**Thorpe on the Hill Parish Council - Interested Party Ref: F29CEB388
Fosse Green Energy (FGE) – Deadline 6**

1. Public Rights of Way

Proposed Permissive Paths Plan

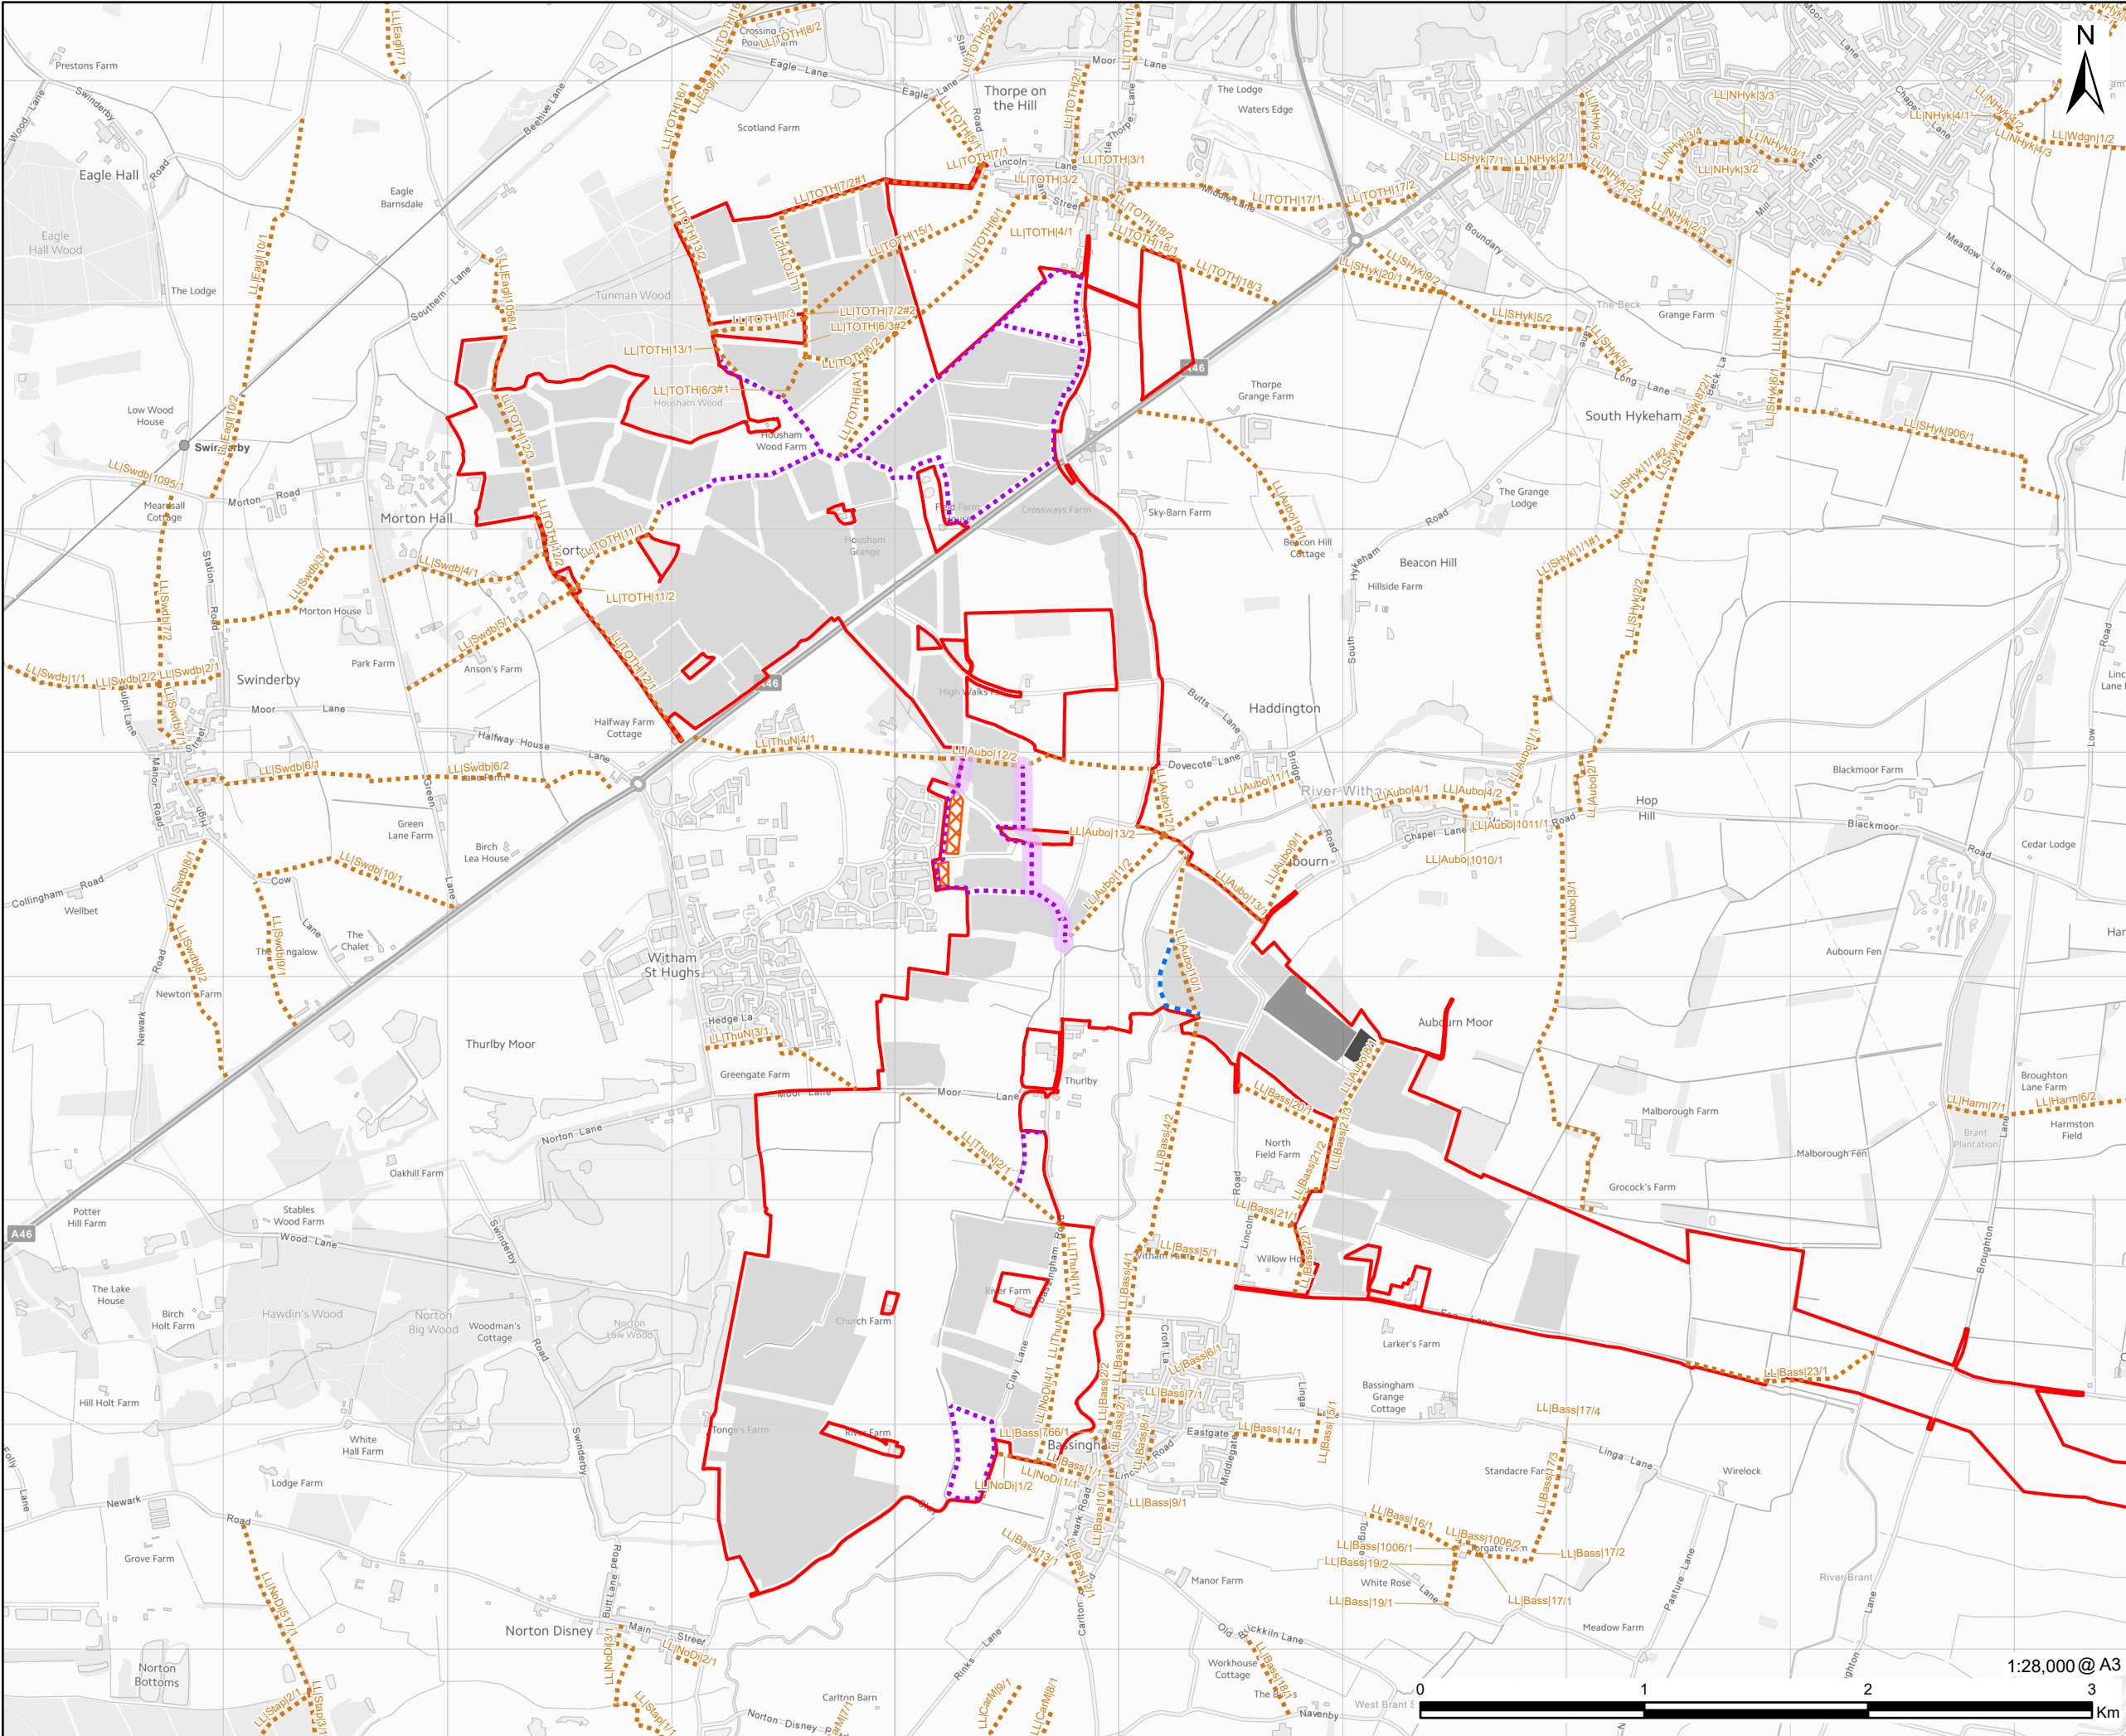
Several proposed changes to footpaths in and around the Stepping Out routes, whilst not necessarily ideal, present largely acceptable work-arounds. However, key sections of the Stepping Out route remain inadequately addressed.

At Deadline 5A TOTH PC's submission REP5A-047 identified that there remain parts of the Stepping Out route that pass-through corridors of solar arrays, i.e., where the fields either side of the path are filled with solar panels or where the proximity of solar panel significantly affects the key views in an adverse manner. In addition is likely that the proximity of panels and equipment close to, and on either side of the paths, will lead to elevated noise levels as referred to in other submissions.

In particular, the footpaths designated as LLTOTH/13/2 and LLTOTH 12/3 on the Applicant's map REP5-008 remain blighted in this manner, and the affected areas identified by the PC in its submission REP5A-047 appear to have been ignored, at least at this stage.

The PC continues to request an improved design at these locations to eliminate, or minimise the described impacts. The PC does not consider that screening will be sufficient or appropriate, and continues to believe that efforts to address the current shortcomings would not materially impact the overall effectiveness of the project, but would dramatically improve the response of local residents and visitors to the area.
